Planning Officer: Ms Myer

Planning Application Ref: BN/22/20/PL

Location: Land South West of 40 Hill Lane, Barnham, PO22 0BL

Description of works: Removal of existing polytunnels & creation of sand school with new native tree & hedge planting

NATIVE PLANTING
Hedging shown green on the plan to consist of a double row of the following native hedging bare root plants 40 – 60cm in height, planted in a random mix.

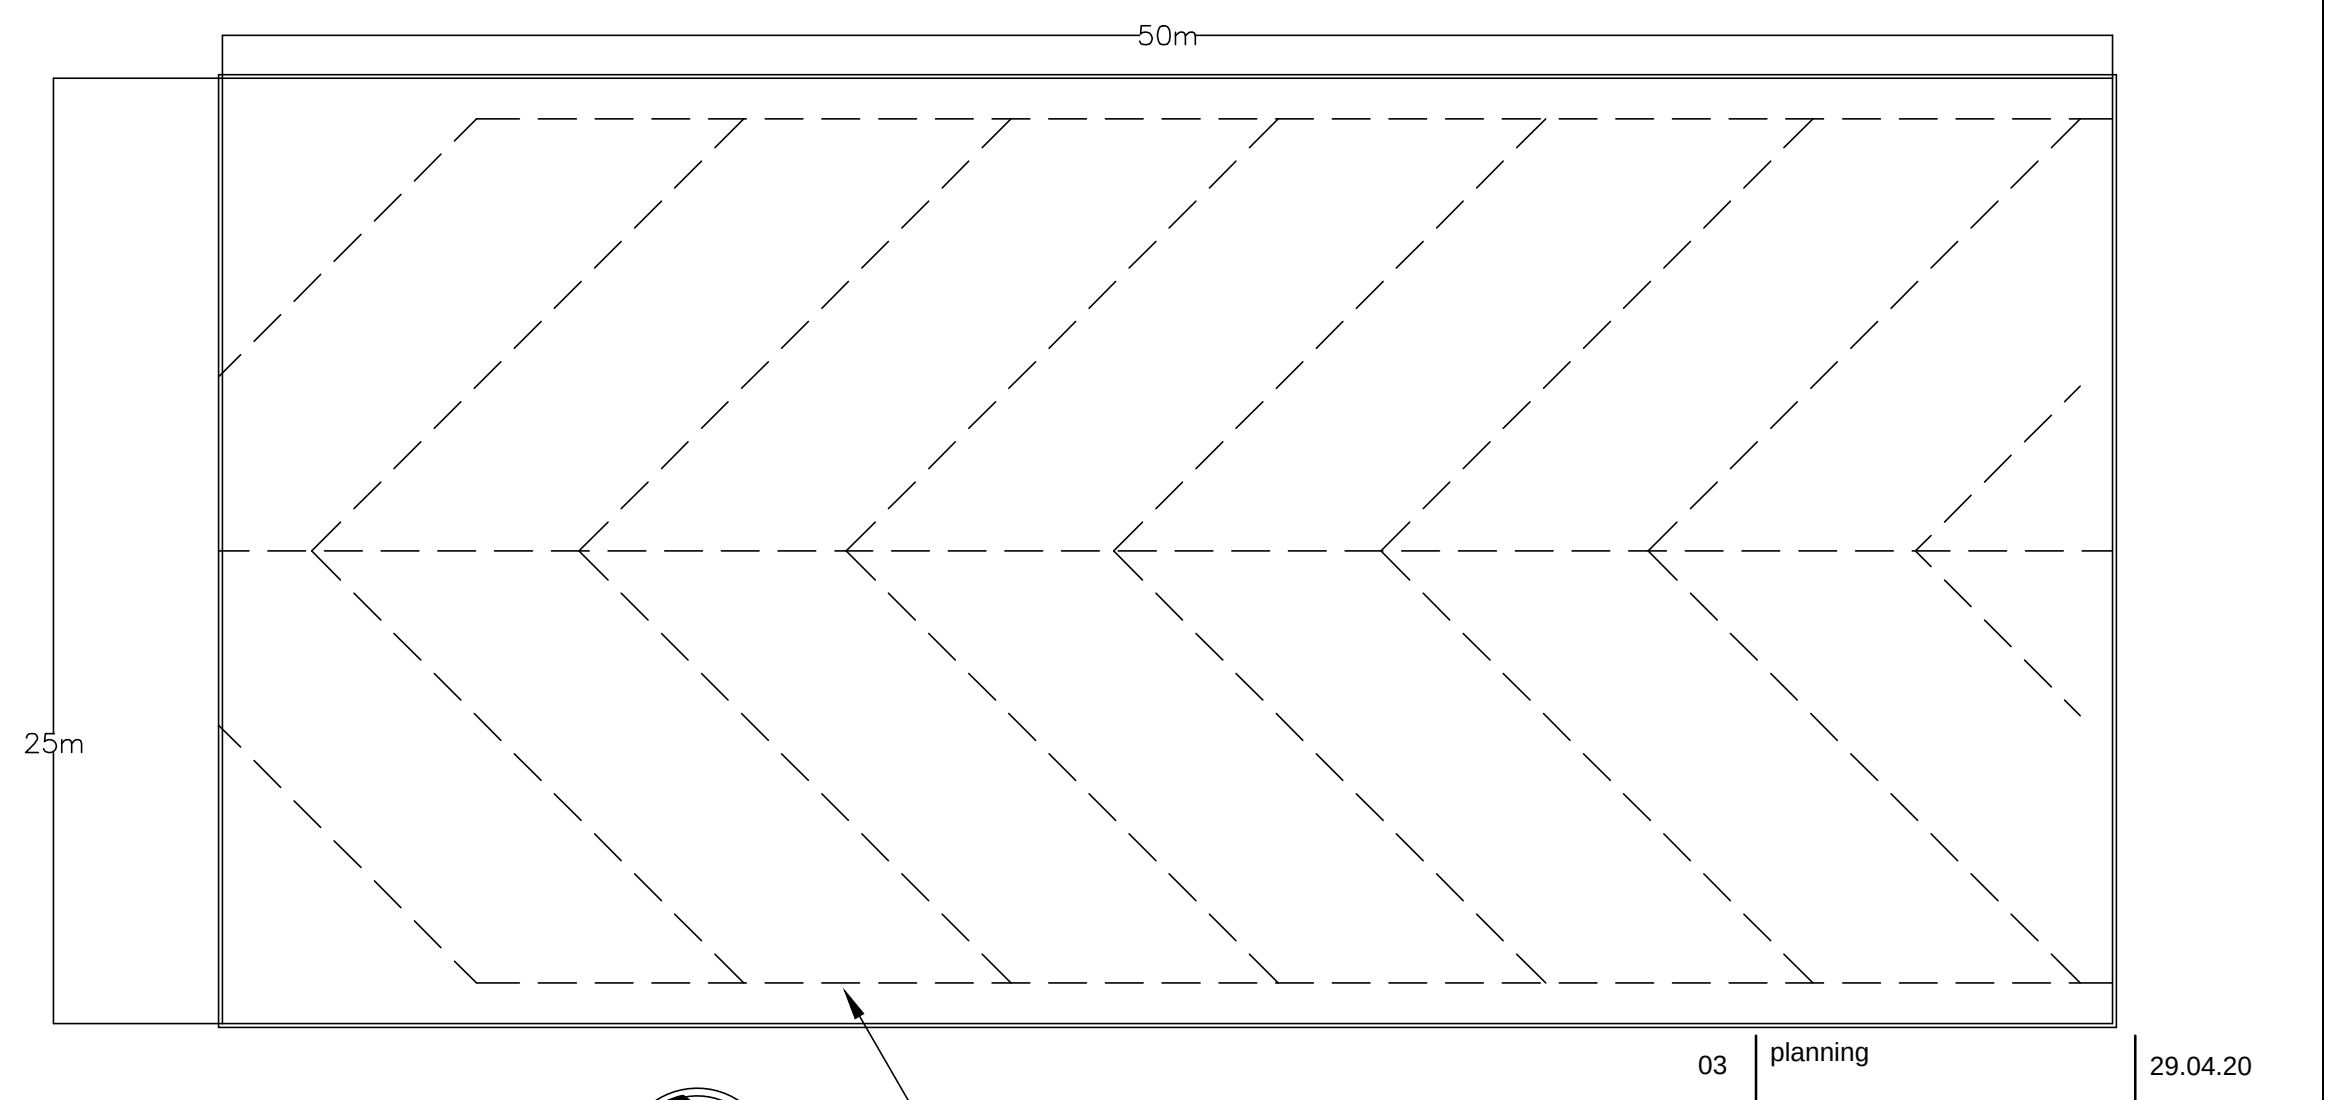
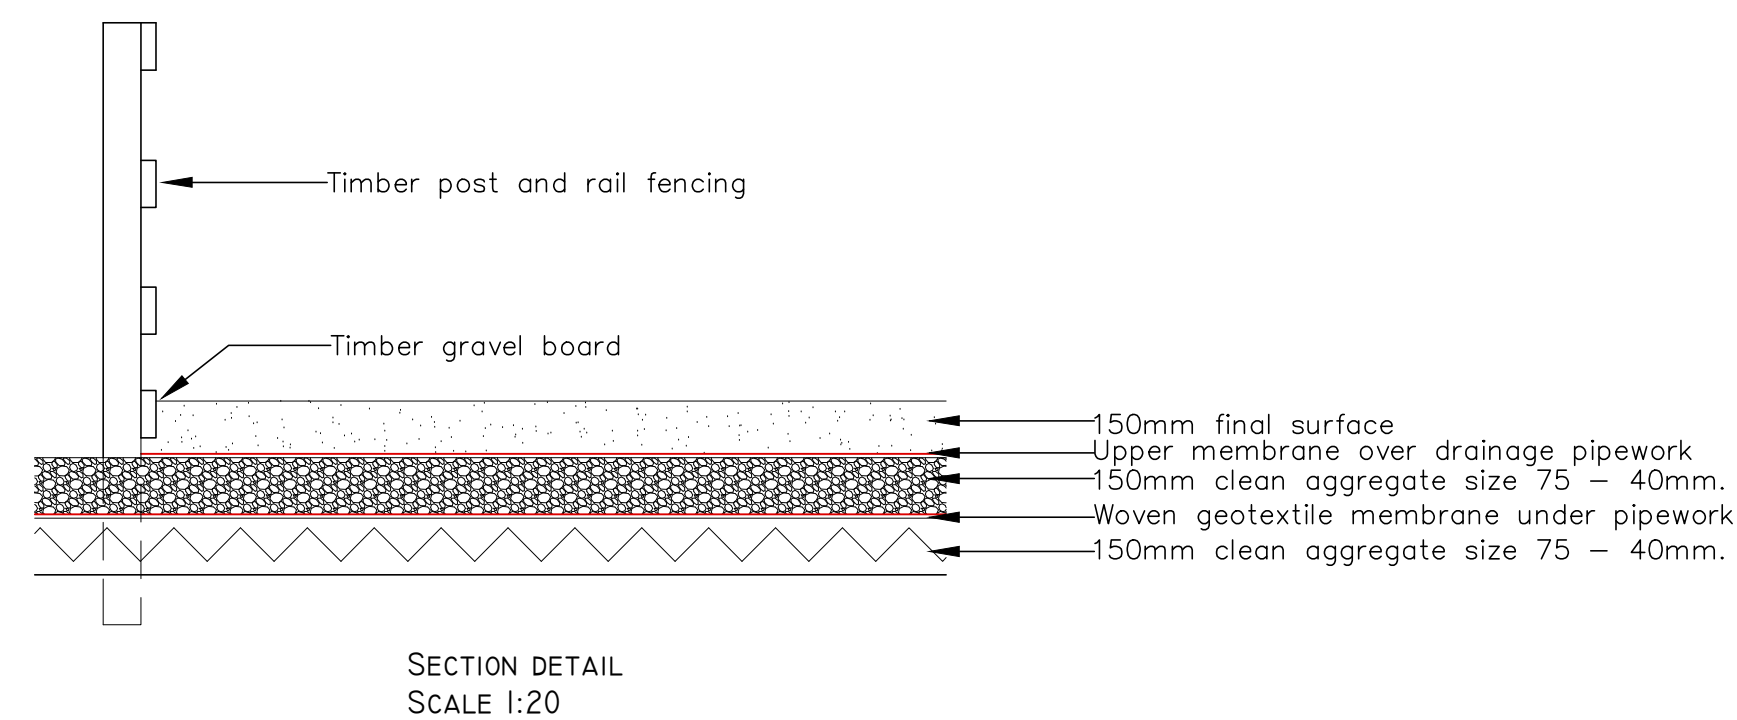
- c) Although the trees within the development appear to be of low quality, we should expect some mitigation for the loss by way of a detailed replacement planting scheme elsewhere on the plot. I see that has been proposed and support the scheme as described on the plan provided by Pope Stevens Architecture Ltd, dwg. no. DPA-01, Rev 02.

- We await confirmation of its viability along the southern boundary where attention has been drawn to potential contamination issues affecting adjacent land (Environmental Health – Consultation Response, April 2020).
Applicant or EH to advise.

- Trees selected to grow as standards within the hedgerow should not adversely affect the existing watercourse on north boundary, if planted at minimum 2m distance from the top of the ditch. **Confirmation required.**

- Online resources suggest native hedgerow exists in part along north (roadside) boundary. Is the proposed planting scheme intended to replace or enhance that feature. **Confirmation required.**
